ENG-MS20001-R4-FDR.pdf Markup Summary

**DEVELOPED DRAINAGE PLAN**

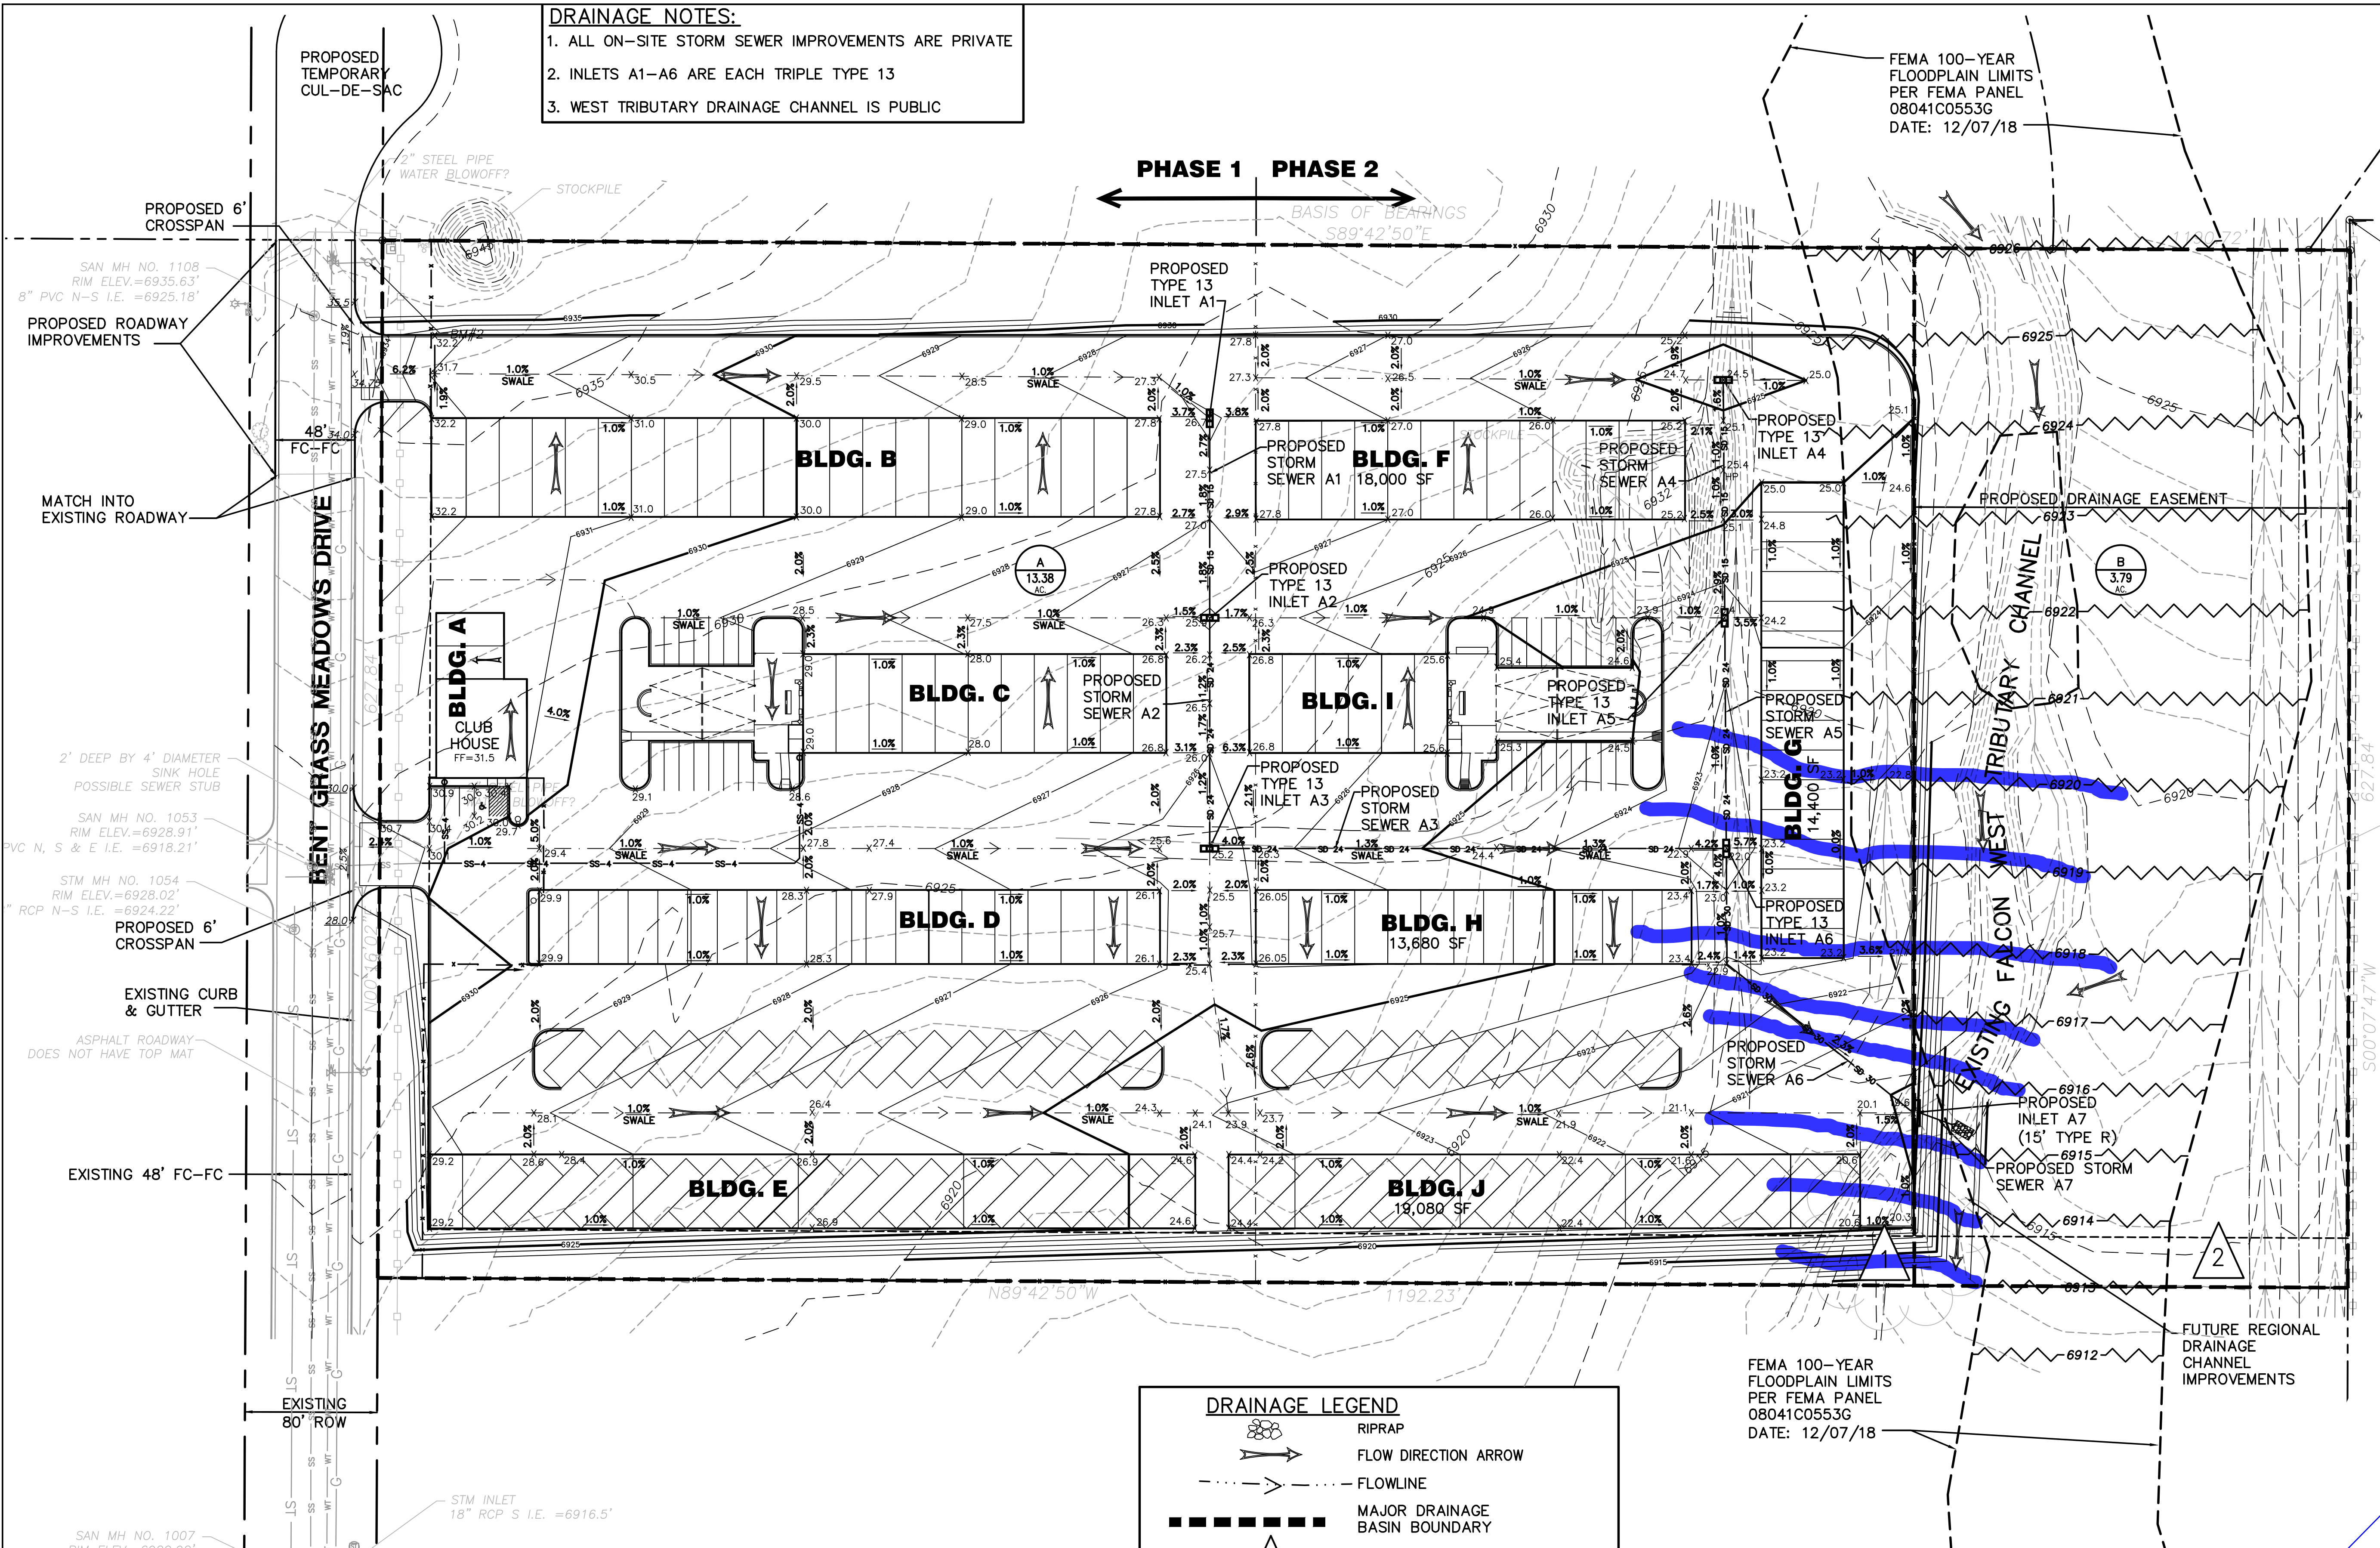
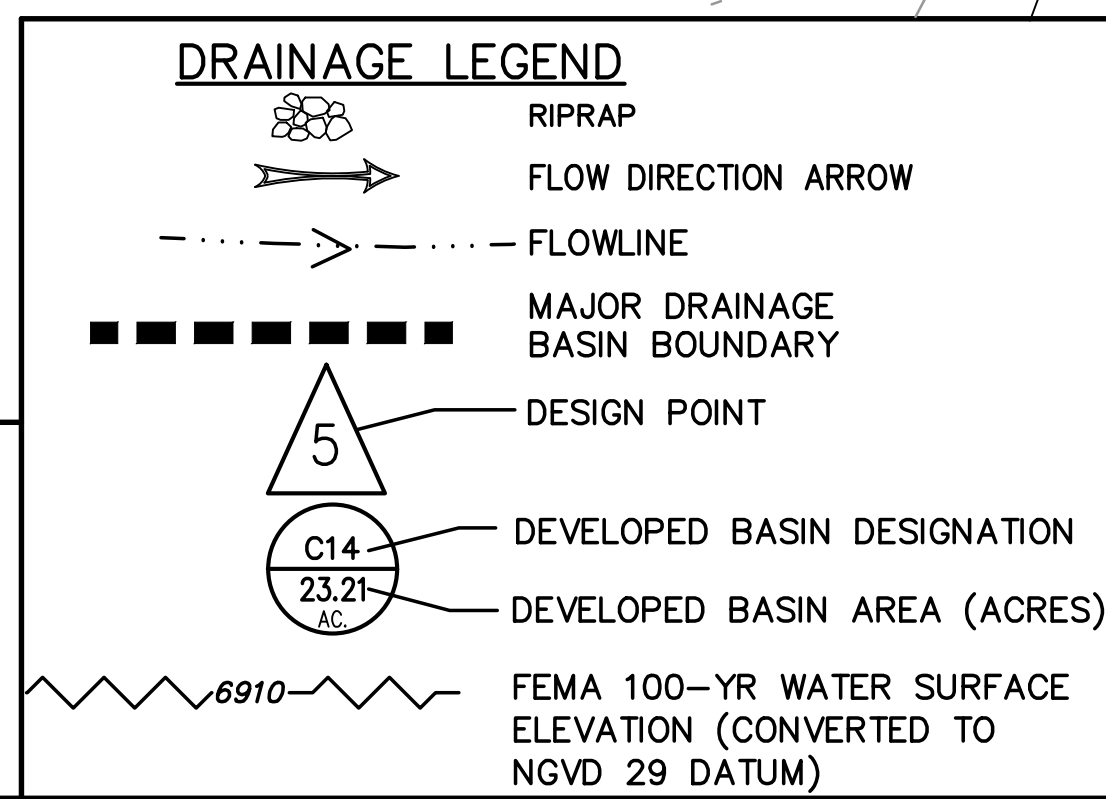
Are these raised islands?

What is the surfacing here?

Is this the ultimate WQ pond location?

Provide ultimate spillway location to flow to channel.

**PHASE 1 DEVELOPED  
 DRAINAGE PLAN**

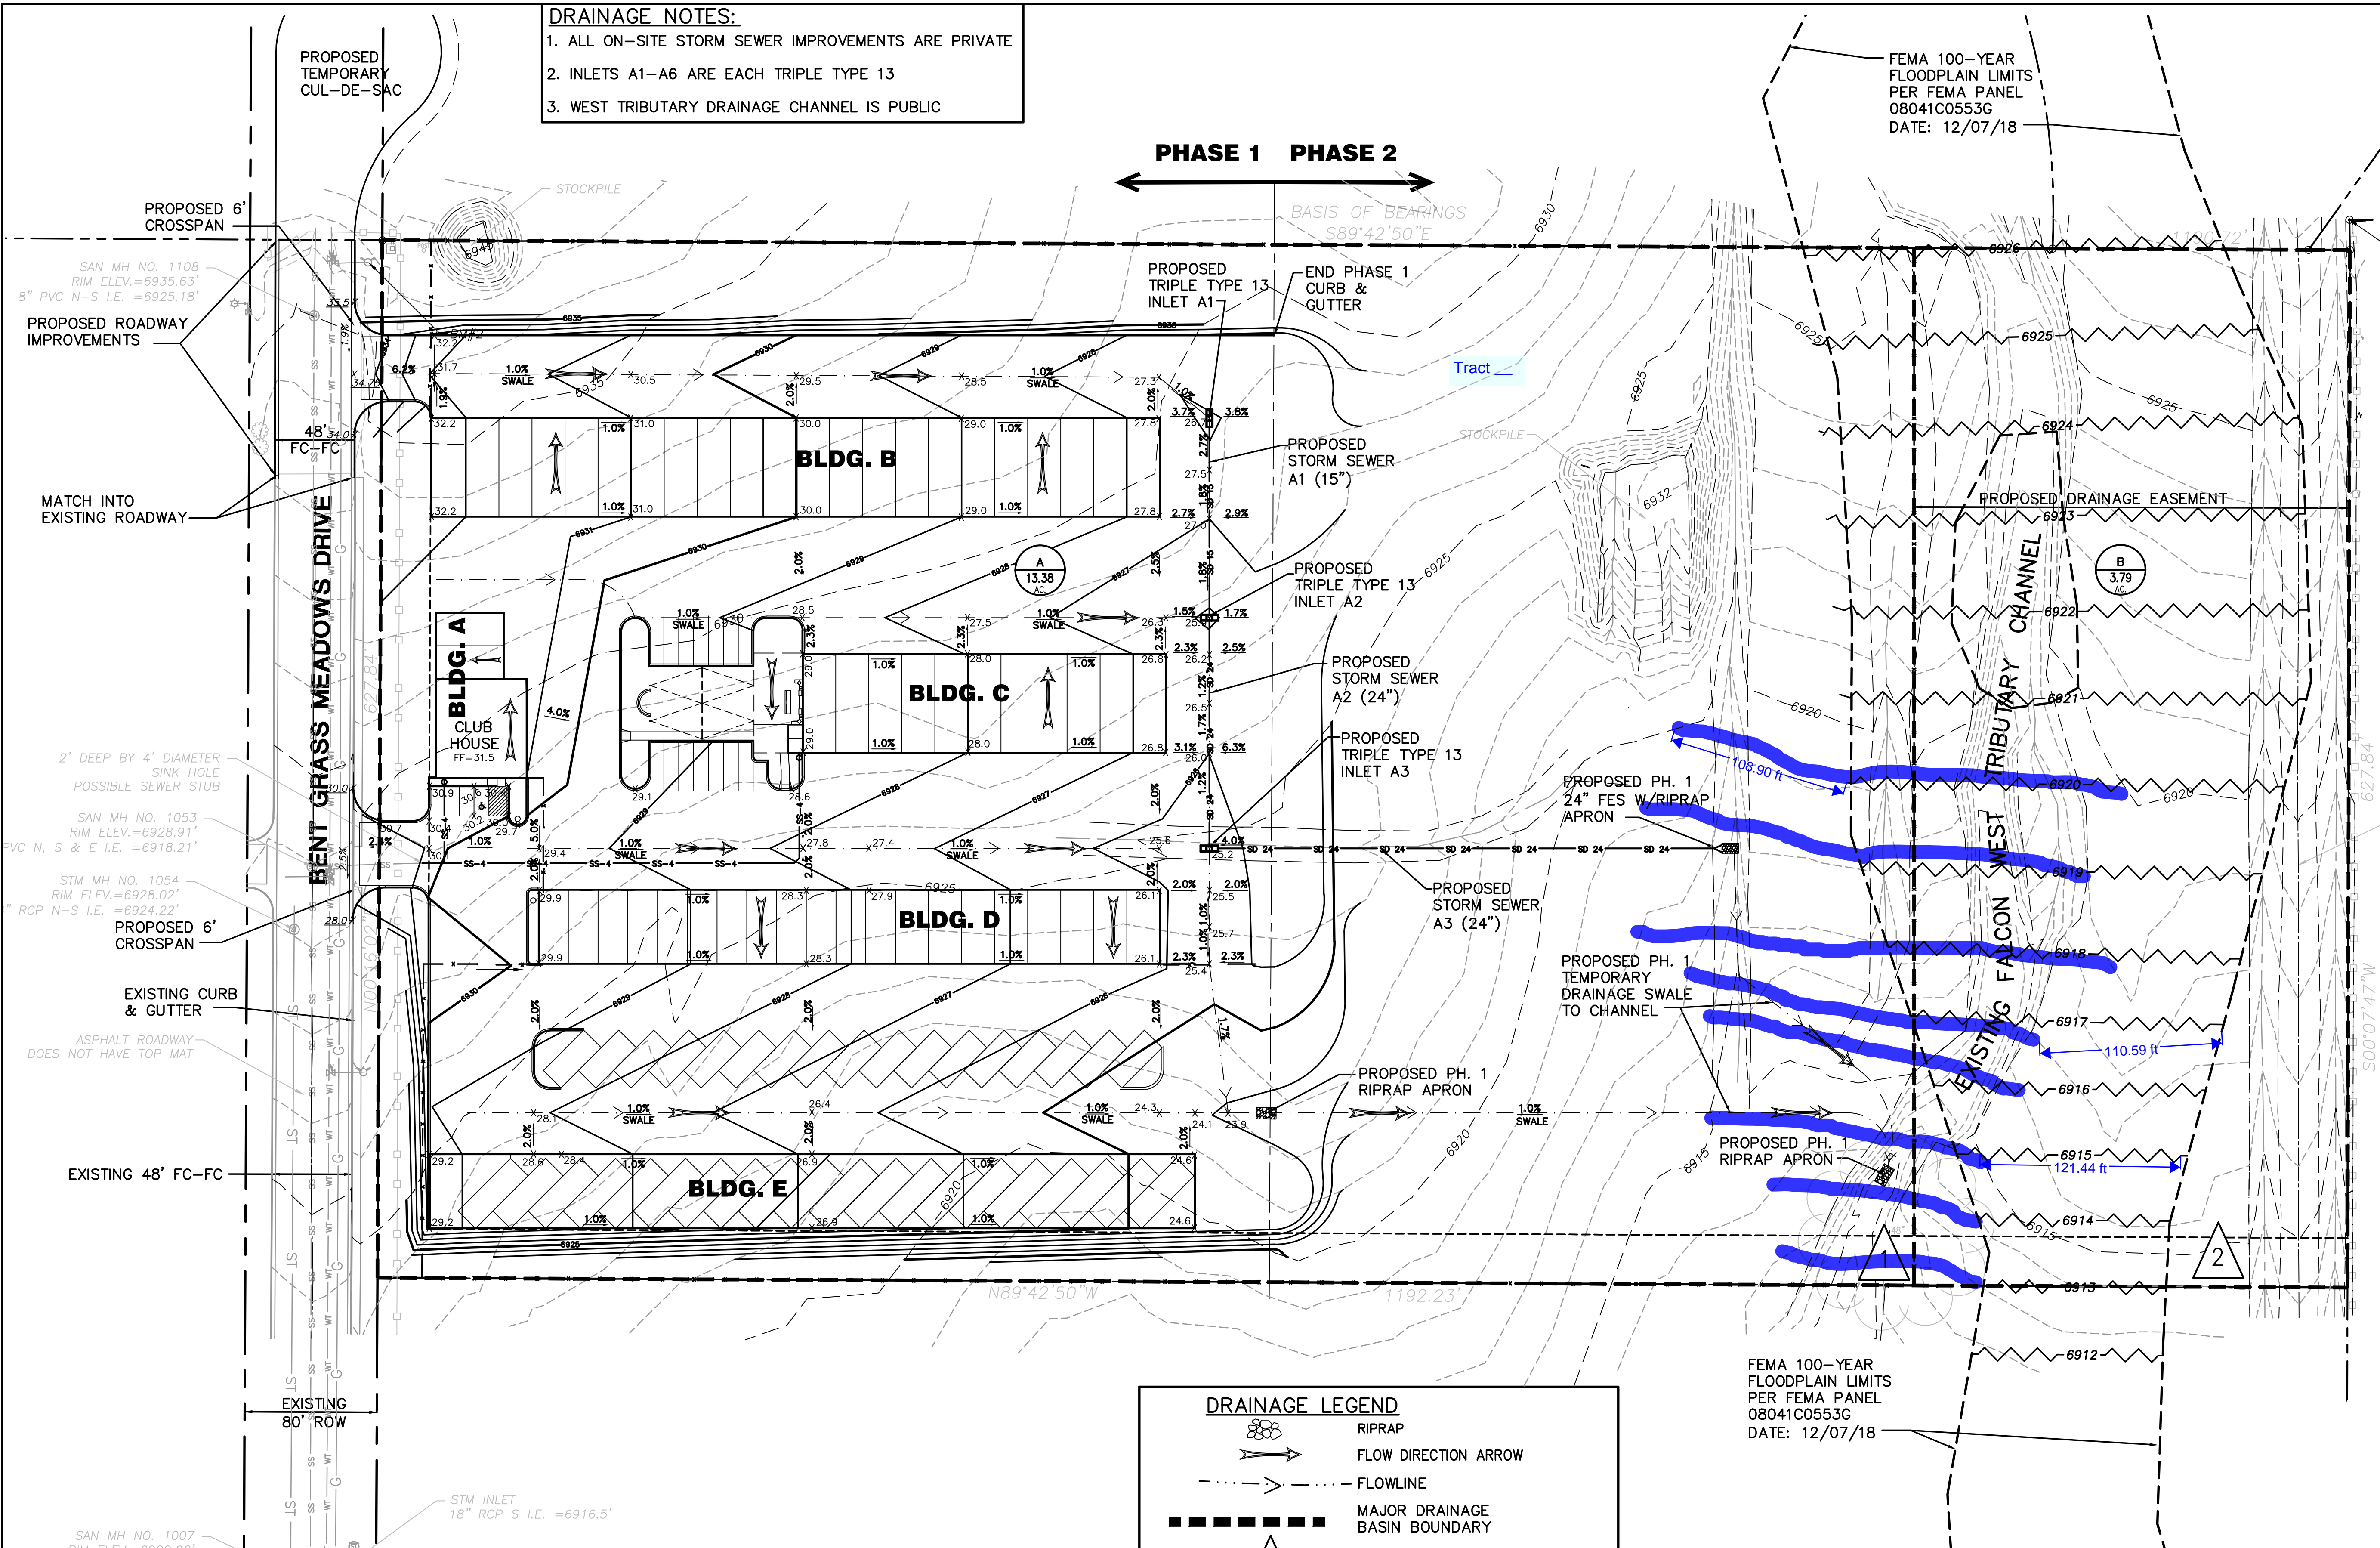
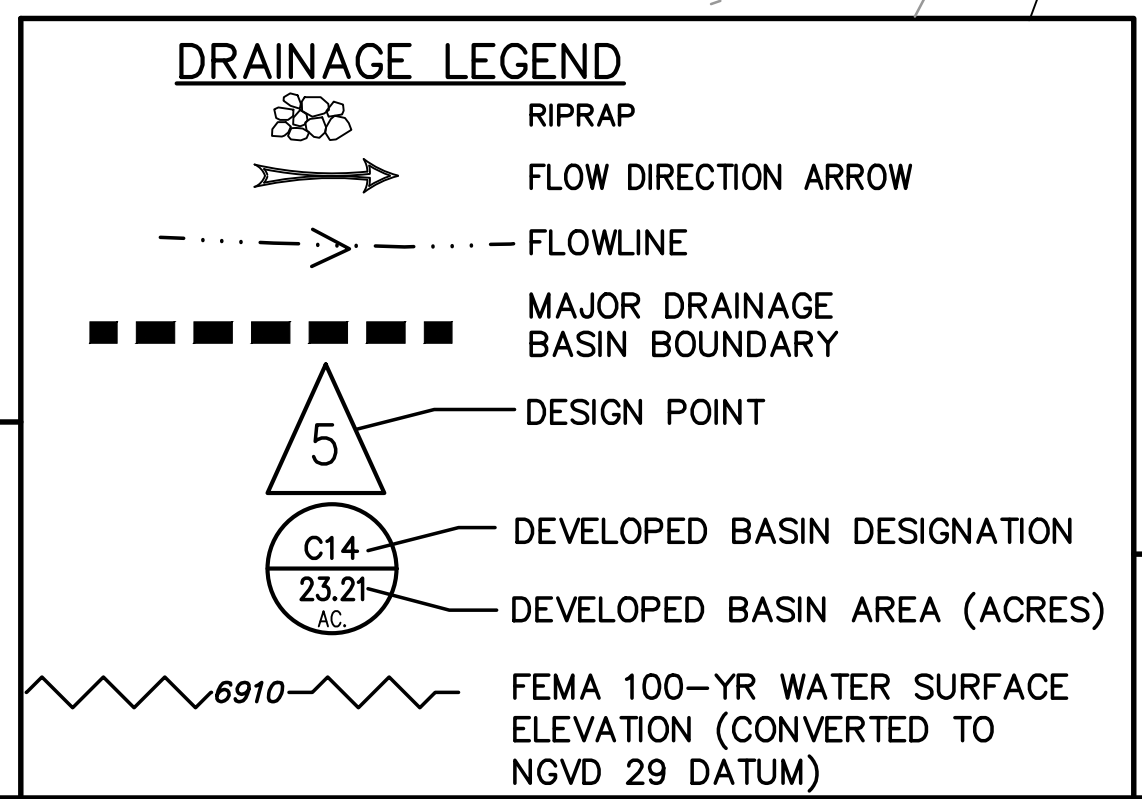
If phase 1 is before the channel is constructed, don't show the channel and adjust pond outfall pipe

Address offsite flow/update existing condition
